KIRKLEES METROPOLITAN COUNCIL INVESTMENT & REGENERATION SERVICE

Reference No:	2023/62/91441/W
Site Address:	31, Chapel Hill, Linthwaite, Huddersfield, HD7 5NJ
Description:	Change of use and alterations to former church (B8-storage) to 9 residential units (C3) and formation of car park (Listed Building within a Conservation Area)
Recommending Officer:	William Simcock

Officer Report – 2023/91441

31 Chapel Hill, Linthwaite

**SECTION A-A THROUGH RAMP AND PARKING DECK**

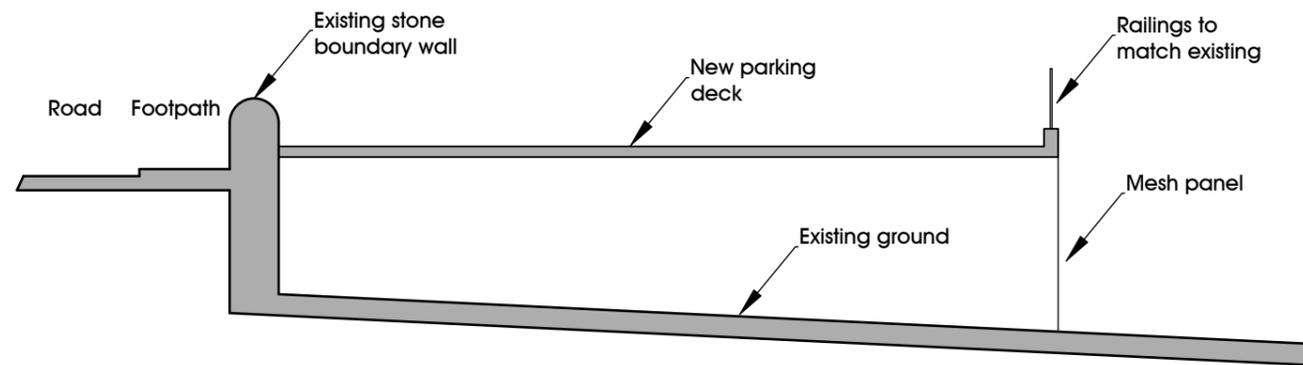
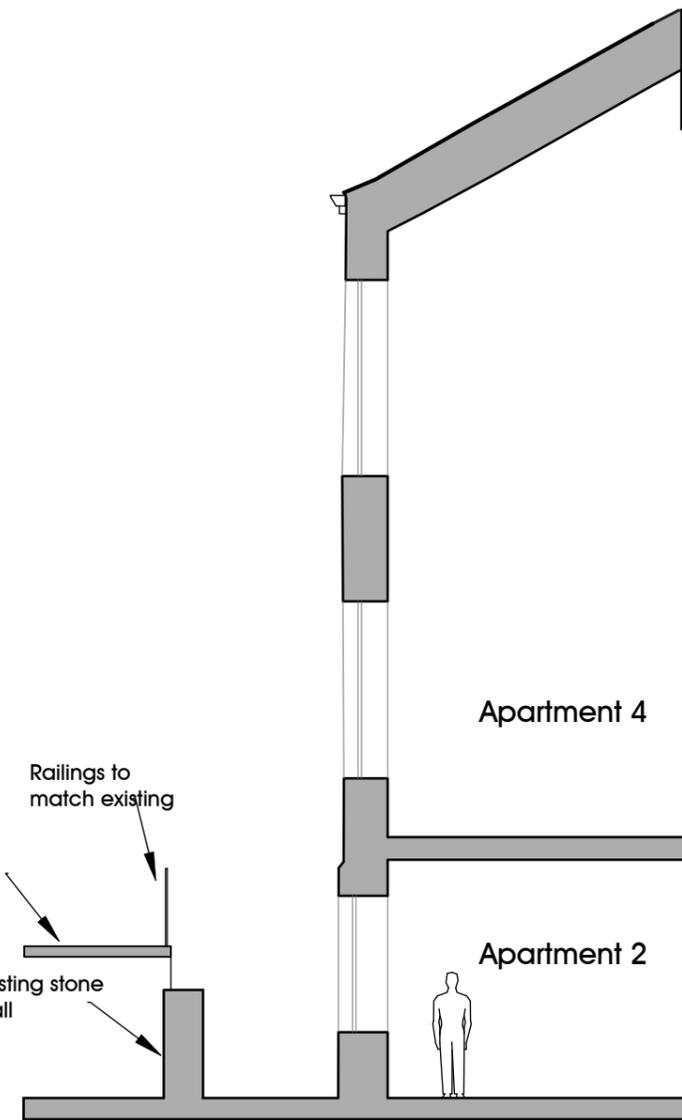
The raising of the parking platform would be most apparent would be at the northern end, where it would, in places, reach to 2.0m above the level of the path which skirts the southern side of the church; whilst it would still be lower than highway level, it would affect views of the Listed Building from the south. Near the southern end of the site, the finished level of the parking deck would be marginally lower than at the northern end but would also be more significantly raised above existing ground levels and would in places be higher

than the adjacent public footway by up to 300mm. Whilst visible from the highway, its impact would however be softened by the retained boundary wall.

It is considered that the loss of the existing soft landscaping and the formation of the raised parking deck would cause a small degree of harm to the setting of the Listed Building and to the character of the Conservation Area. The degree of harm would in both cases be less than substantial and it is considered it would be justified since there would otherwise be no reasonably practical way of accommodating parking within the site. The alternative, of allowing the scheme with no off-street parking, is not considered acceptable (see relevant section below).

- Before work commences on the formation of the parking deck, details of its surfacing, including the aggregate mix if a concrete finish is to be used, shall be submitted.

PROPOSED WEST ELEVATION 1:100

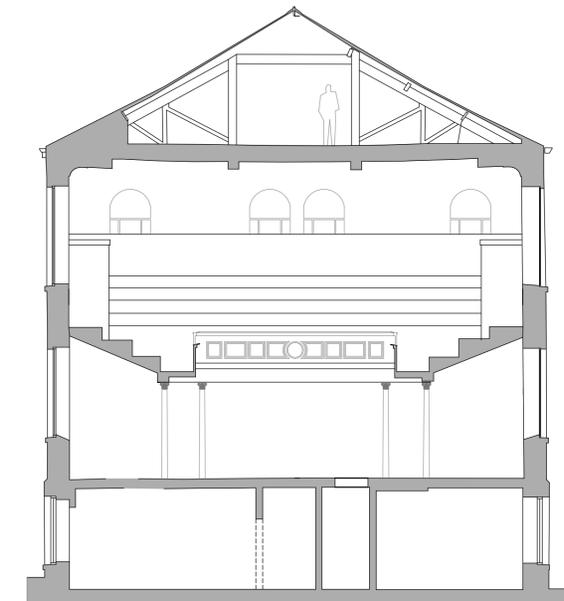
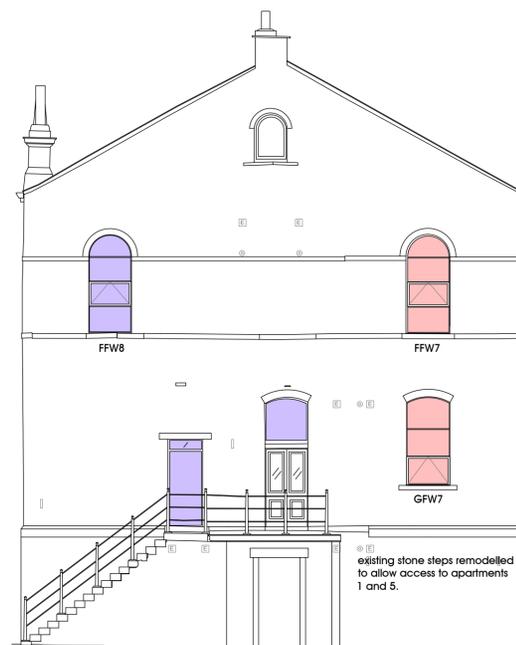
KC Conservation and Design expressed concern that the window apertures to GFW11 and GF14 appeared to be of different heights (based on photographic images, even though the plans show them to be the same dimensions) and that the relocated window might not fit in the aperture. The applicant's agent was notified of this concern and confirmed that the window apertures are in fact the same height. The case officer accepts this, and in the event that further alterations are required after all, an application to vary the Listed Building Consent will need to be sought. The latest version of the elevations shows that window FF14 is to be relocated and encapsulated.

Drawing:
Window
Details

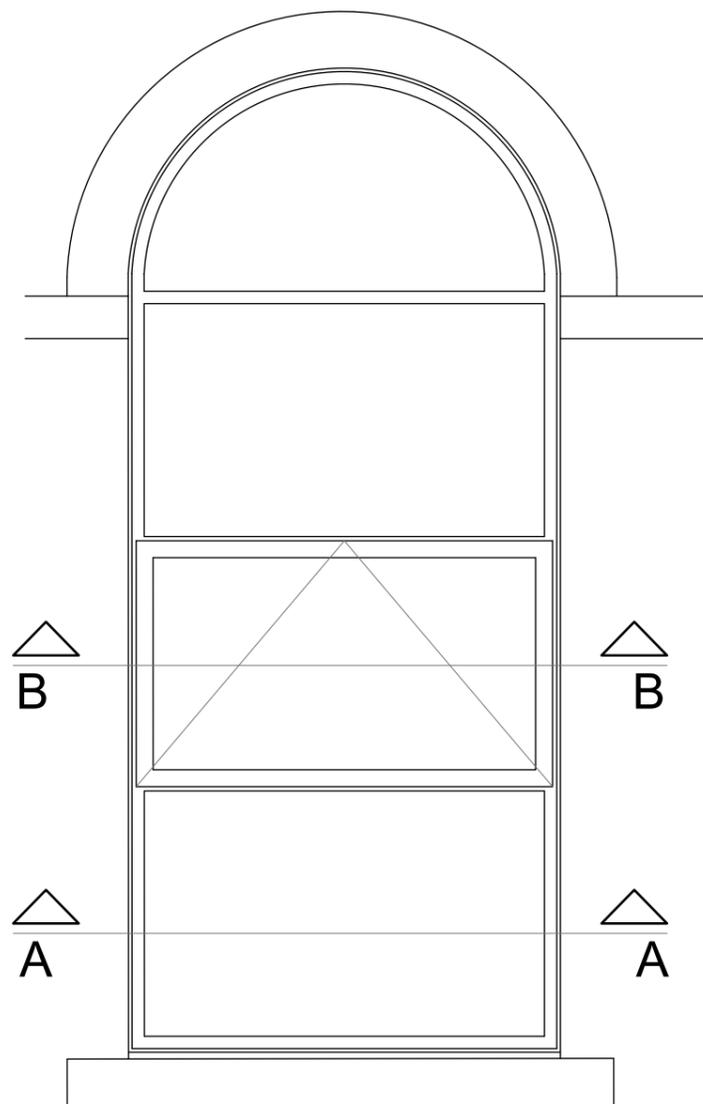
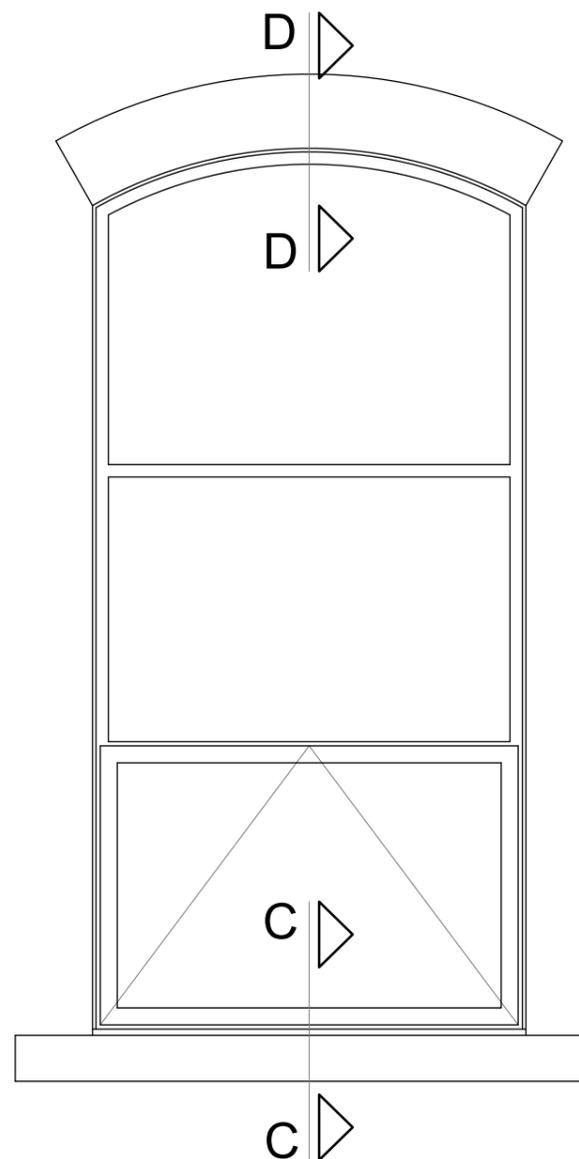
The lower ground floor windows (those to the former caretaker’s flat) are timber-framed sliding sash windows. It is proposed to replace these with steel-framed casement windows. The applicant has ruled out the option of steel-framed sliding sash windows since the manufacturer they have chosen to supply the main window frames for the building does not supply them, and metal-framed windows are preferred by the applicant on the grounds of cost and ease of maintenance. Whilst there are manufacturers who make steel sliding sash windows, it is noted that relying on different manufacturers to supply windows for different parts of the building would be likely to increase costs and would possibly result in a less cohesive appearance to the development once finished. The retention of timber-framed sash windows (or their like-for-like replacement) at lower ground floor would ideally have been preferred from the point of view of heritage conservation. It is noted however that these windows are not one of the more prominent architectural features of the building and it is considered their contribution to the building’s historical interest and significance are minimal – indeed they are not explicitly mentioned in the Listing description. The change in window style and materials in this part of the building can be accepted in principle since the degree of harm to the character of the building would, at most, be very minor and certainly less than substantial, and would in this case be outweighed by the practical benefits in assisting the building’s long-term conservation, provided that the pattern of glazing divisions reflects that of the existing windows.

- Full details including elevations at 1/20 scale and sections at 1/5 of all new or replacement windows and window frames. (The submitted details appear to be generally acceptable, but since scaled drawings have not been included, this cannot be ascertained without detailed elevations and sections or a specimen to be installed and approved after inspection on site. The submitted details should therefore be treated as indicative).
